## OFFICER'S REPORT

APPLICATION NUMBER: S6/2003/1311/FP

LOCATION: Wyndham Cottage, Camfield Place, Essendon

PROPOSAL: Erection of two storey side extension and rear conservatory

DRAWING NO2, DATE AUG 03, SCALE 1:50 METRE  
 FOR FREE HOLDERS MR. MRS ADKIN  
 ADDRESS WYNDHAM COTTAGE, CANFIELD PLACE, ESSENDON HERTS ALGEE  
 FRONT, BACK, SIDE, ELEVATIONS SHOWING EXISTING AND PROPOSED  
 EXTENSION + CONSERVATORY

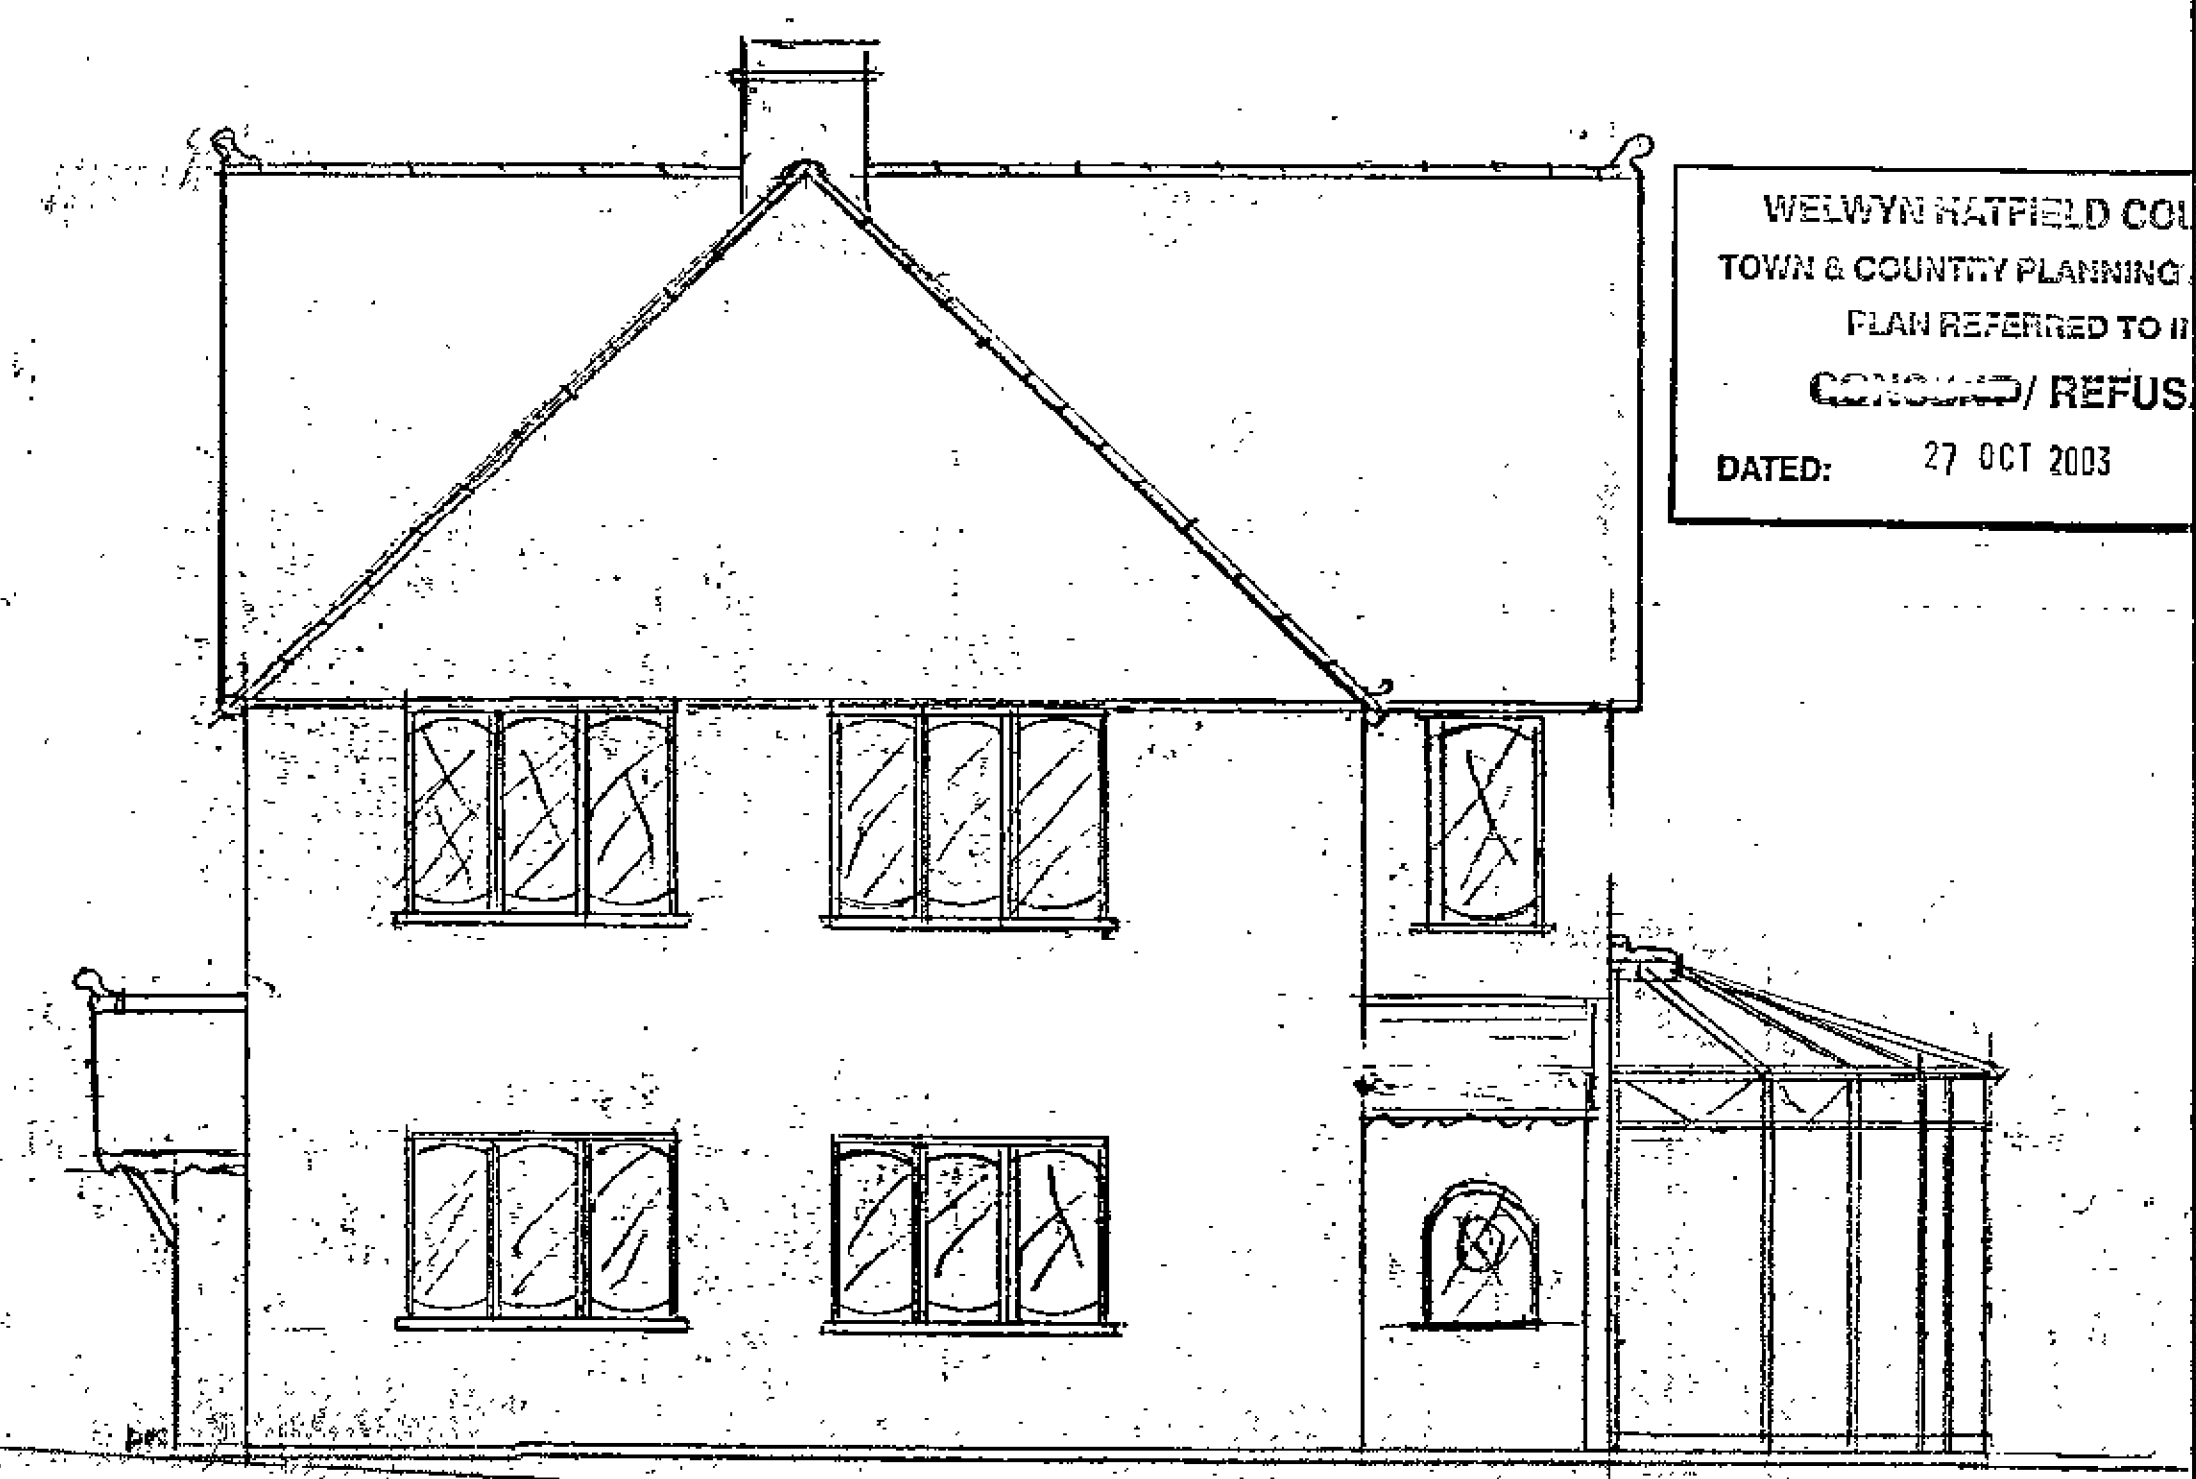
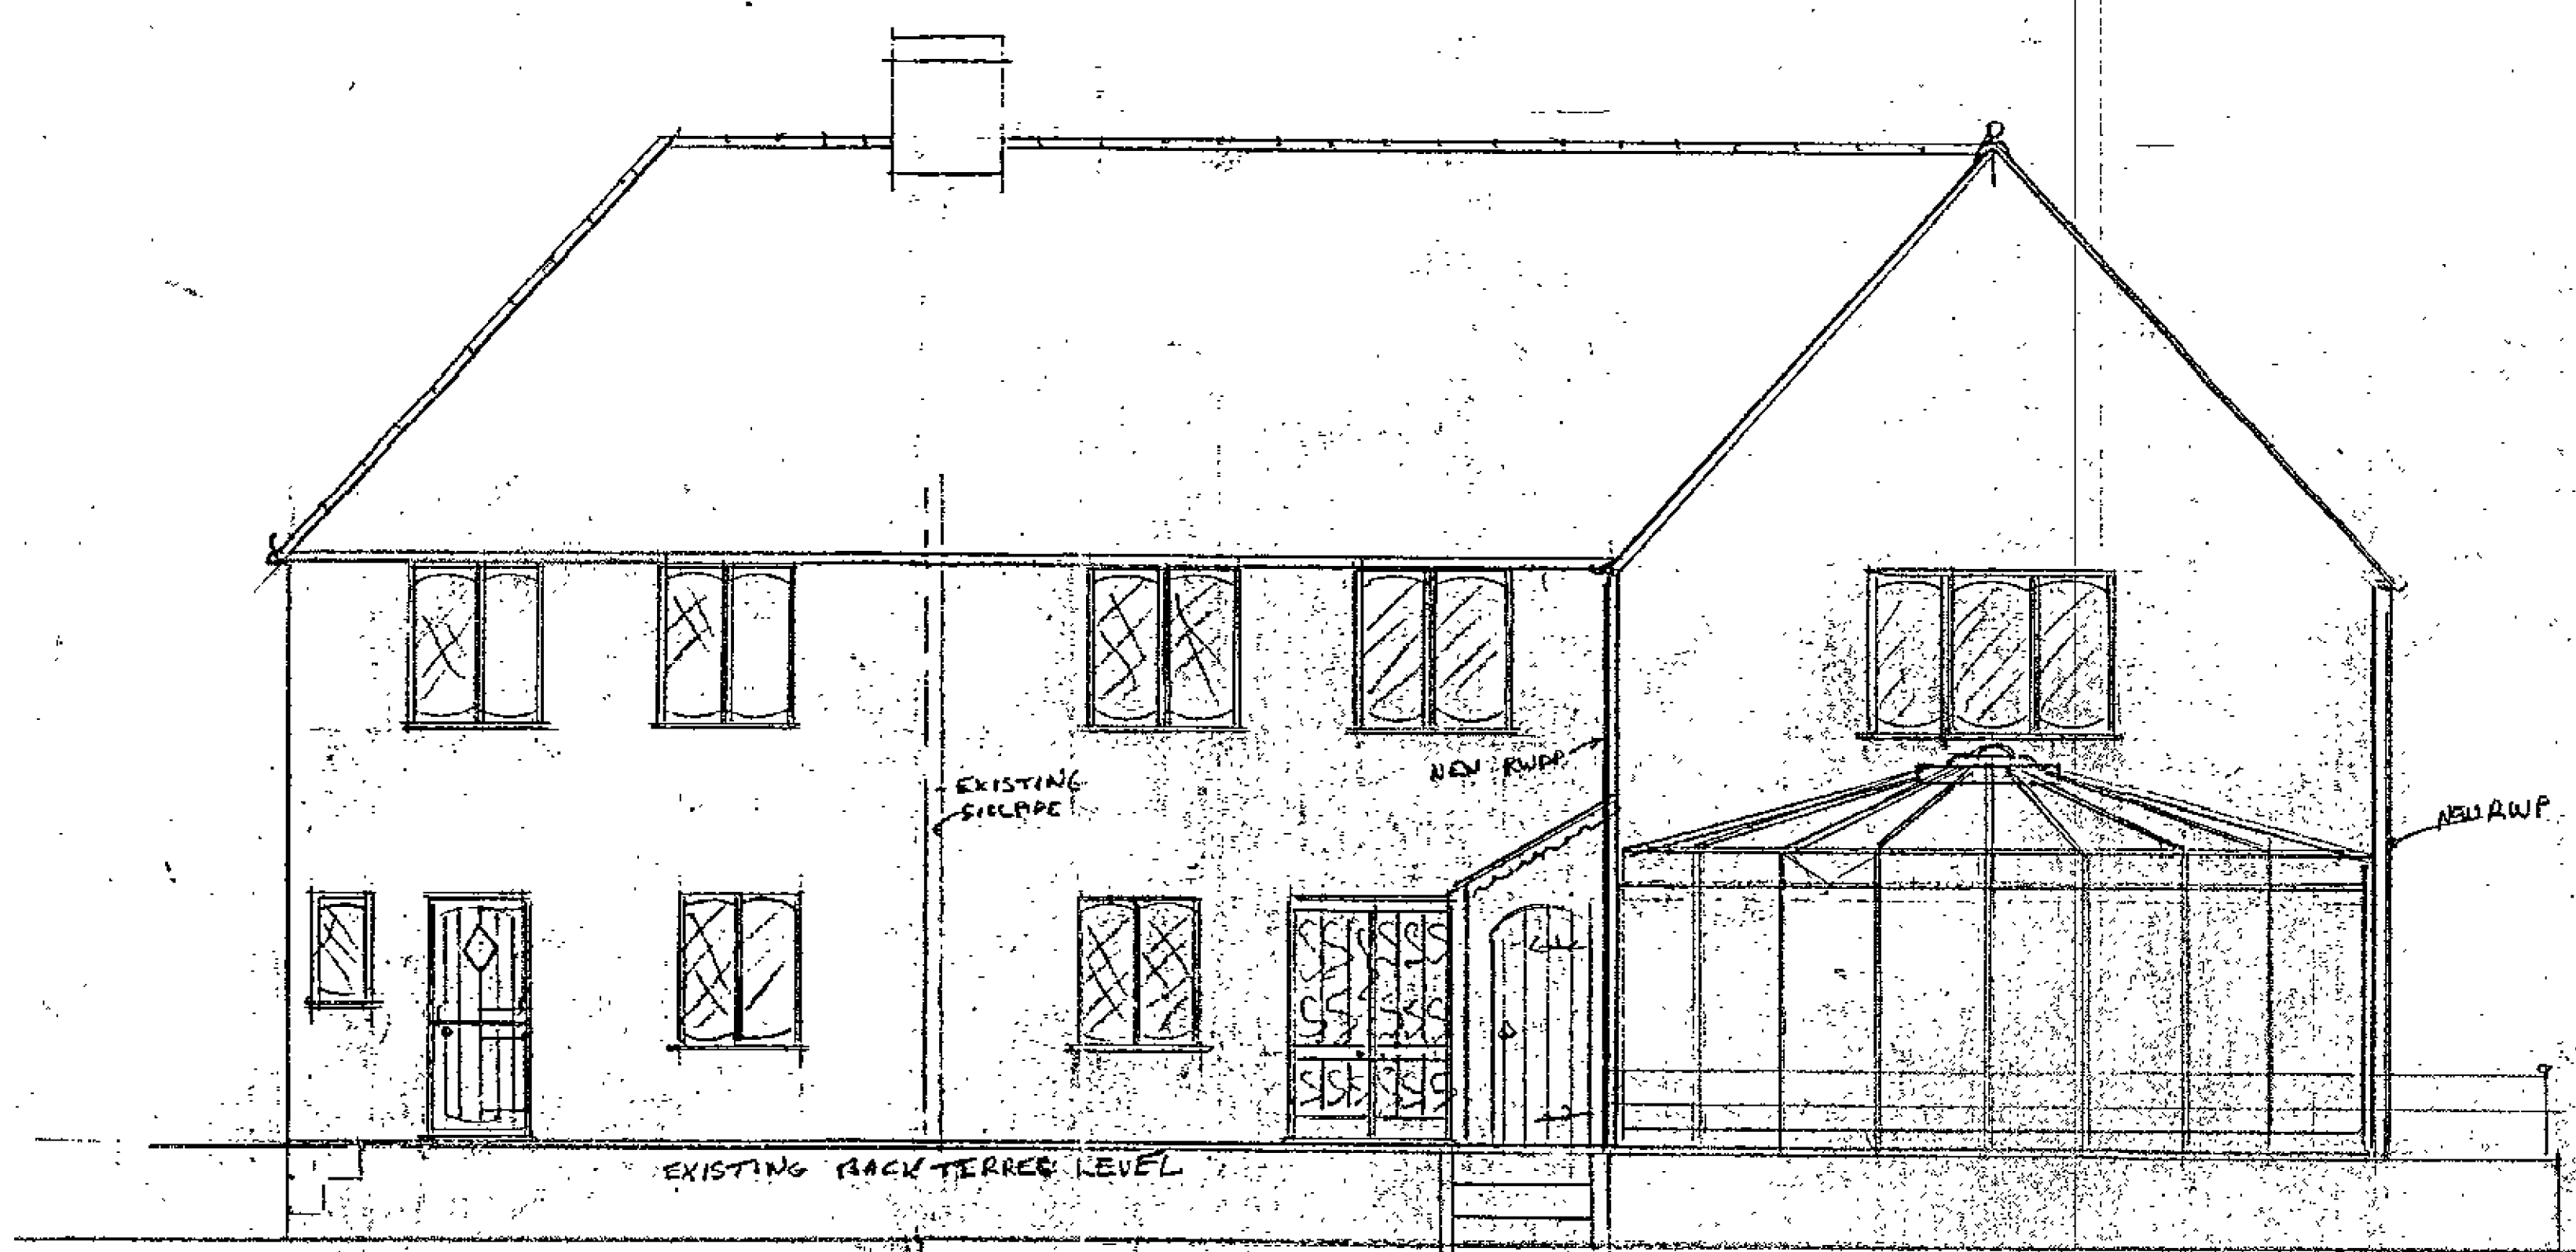
The proposals have been assessed in terms of policy GB3 and GB5. The garage and green house buildings, although not an extension have already substantially increased the built form in this rural location. The proposed extension will add further to the dwelling itself. The extensions proposed, particularly when viewed in association with the garage are disproportionate to the size of the original dwelling. When considered alone they represent a 67% increase, however if including the garage and glasshouse as well it would represent a floorspace increase of 109%. The site is well screened from the road and surrounding area and therefore no adverse visual impact will result. In terms of the size and bulk however the proposals do not accord with policy GB3, GB5, RA1 or RA3.

In terms of the Council's Residential Criteria, the application is also not acceptable. The extension would not be subordinate to the original dwelling and does not reflect the design or character of the house through the introduction of a gabled roof. The extension would also visually unbalance the appearance of the dwelling. Due to its isolated location and position away from the road the extension will accord with all other aspects of this policy.

1. The proposed extensions will result in a disproportionate increase in the size and bulk of the original dwelling and as such will harm the openness of the Green Belt contrary to policies GB3 and GB5 of the Welwyn Hatfield District Plan, Alterations No. 1, adopted March 1998 and policies RA1 and RA3 of the Welwyn Hatfield District Plan Review, Revised Deposit Version, published June 2002.
2. The proposed extensions are not subordinate to the original house and do not reflect the design or character of the original dwelling and as such will harm the appearance of the dwelling contrary to the requirements of policy Res Criteria 22 of the Welwyn Hatfield District Plan, Alterations No. 1, adopted March 1998 and Supplementary Design Guidance, Welwyn Hatfield District Plan Review, Revised Deposit Version, published June 2003.
